3/17/26

I-5719B_U5800_Submittal S-008-4B Plans
MI-Engineering- Hydraulics Review

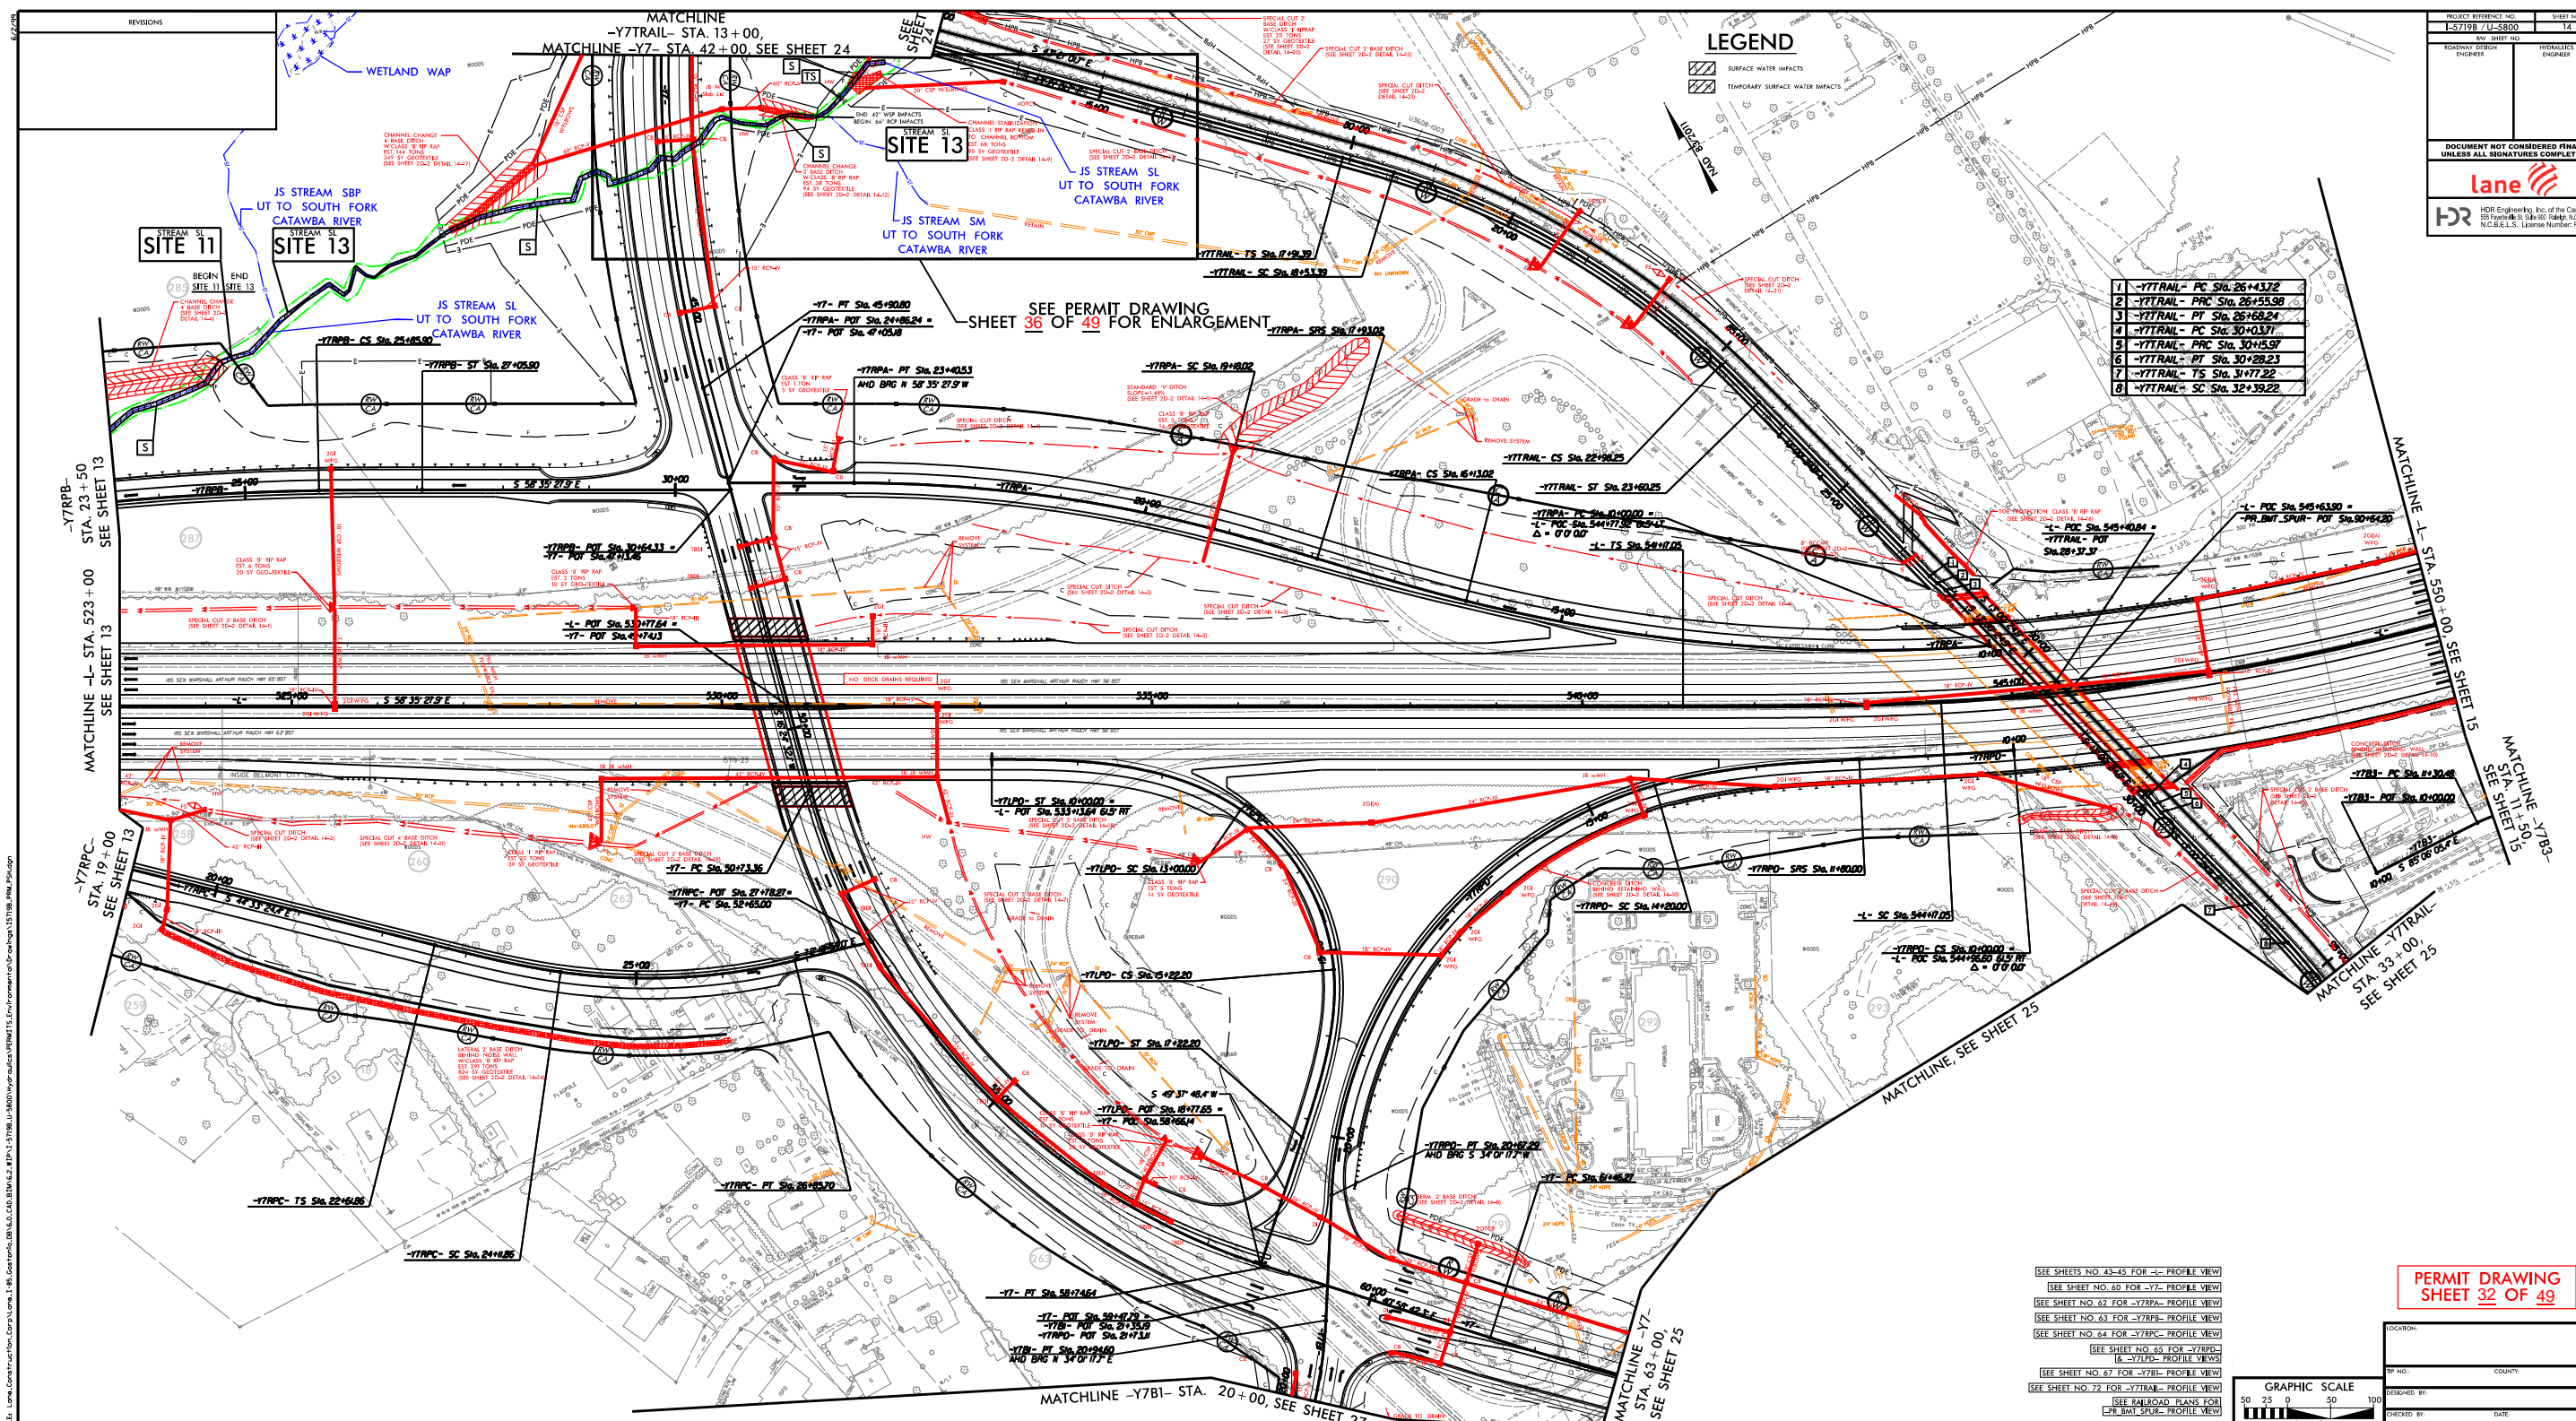
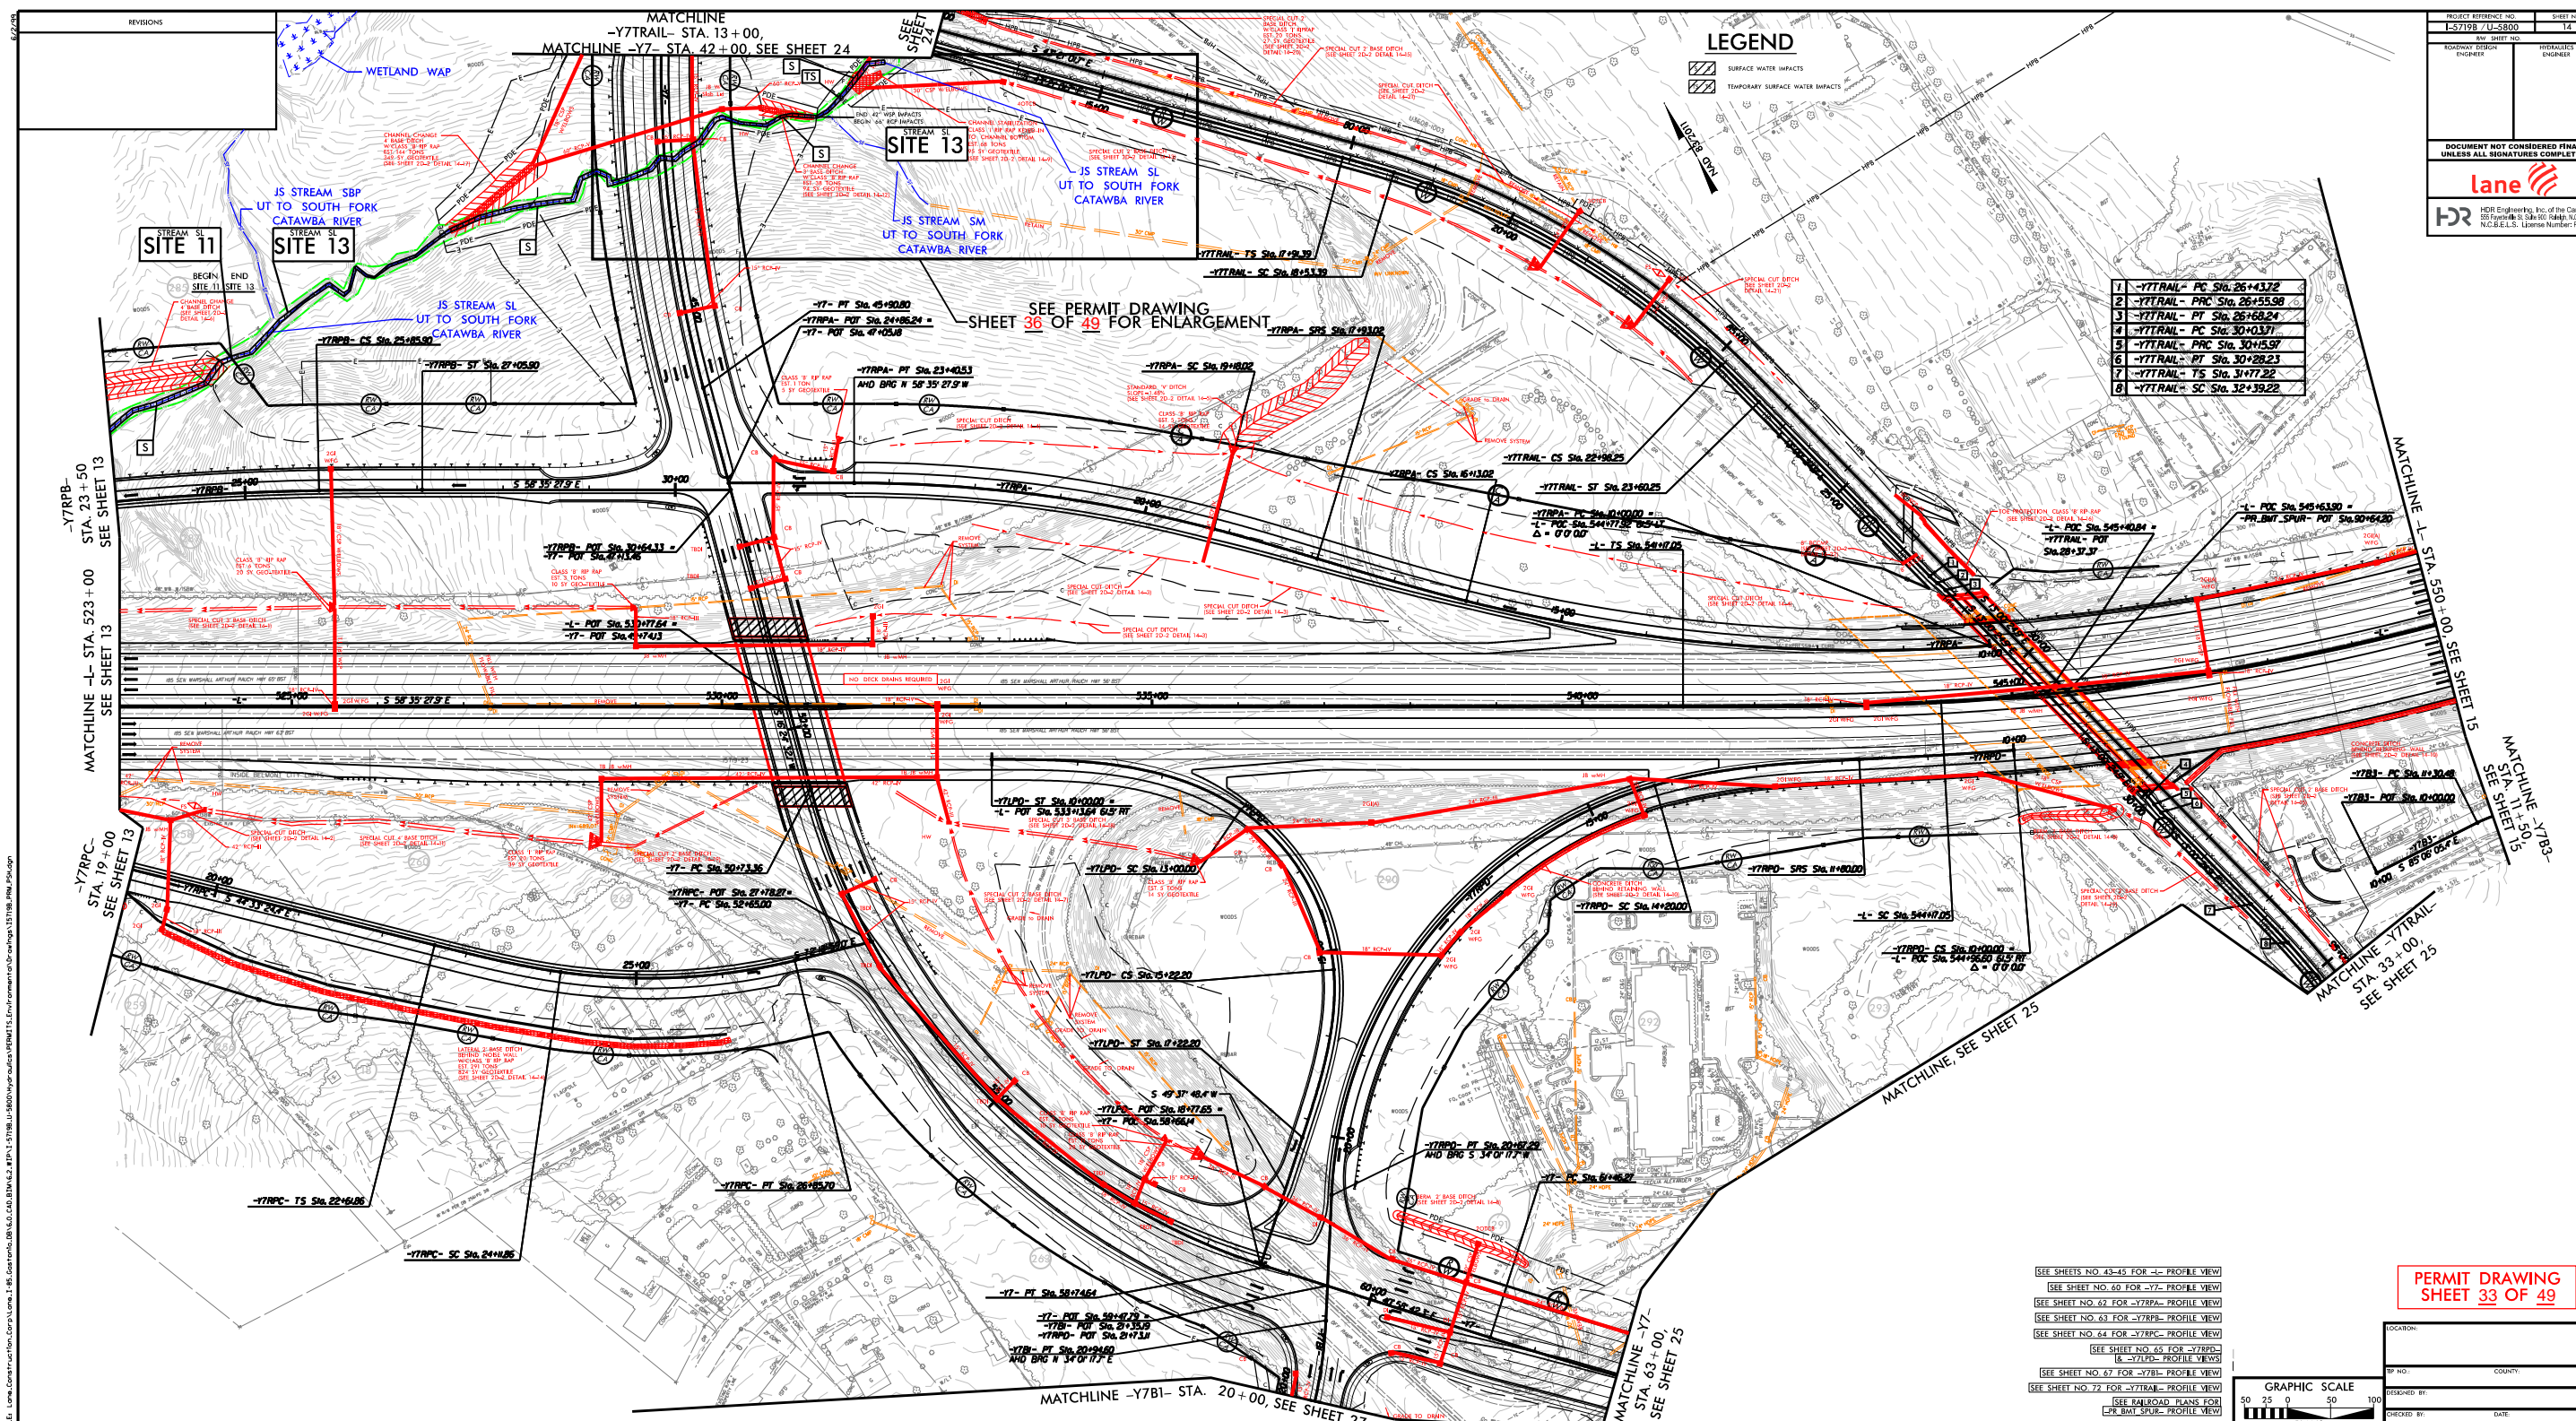
- 66" pipe at station 42+83 -Y7-. The proposed alignment is not the best way to match the existing channel alignment. Be prepared to defend. Does it result in more channel impacts compared to if a straight alignment was used? Does slope match existing channel slope ect..
 - The offset alignment was requested by the contractor to improve construction sequencing/duration.
- 42" pipe at station 13+59 -Y7TRAIL. Is rip rap needed in outlet channel. The slope of pipe is steep and outlet velocities high. May be good to show it embedded in stream bed.
 - Riprap was revised to show key-in to channel bottom.
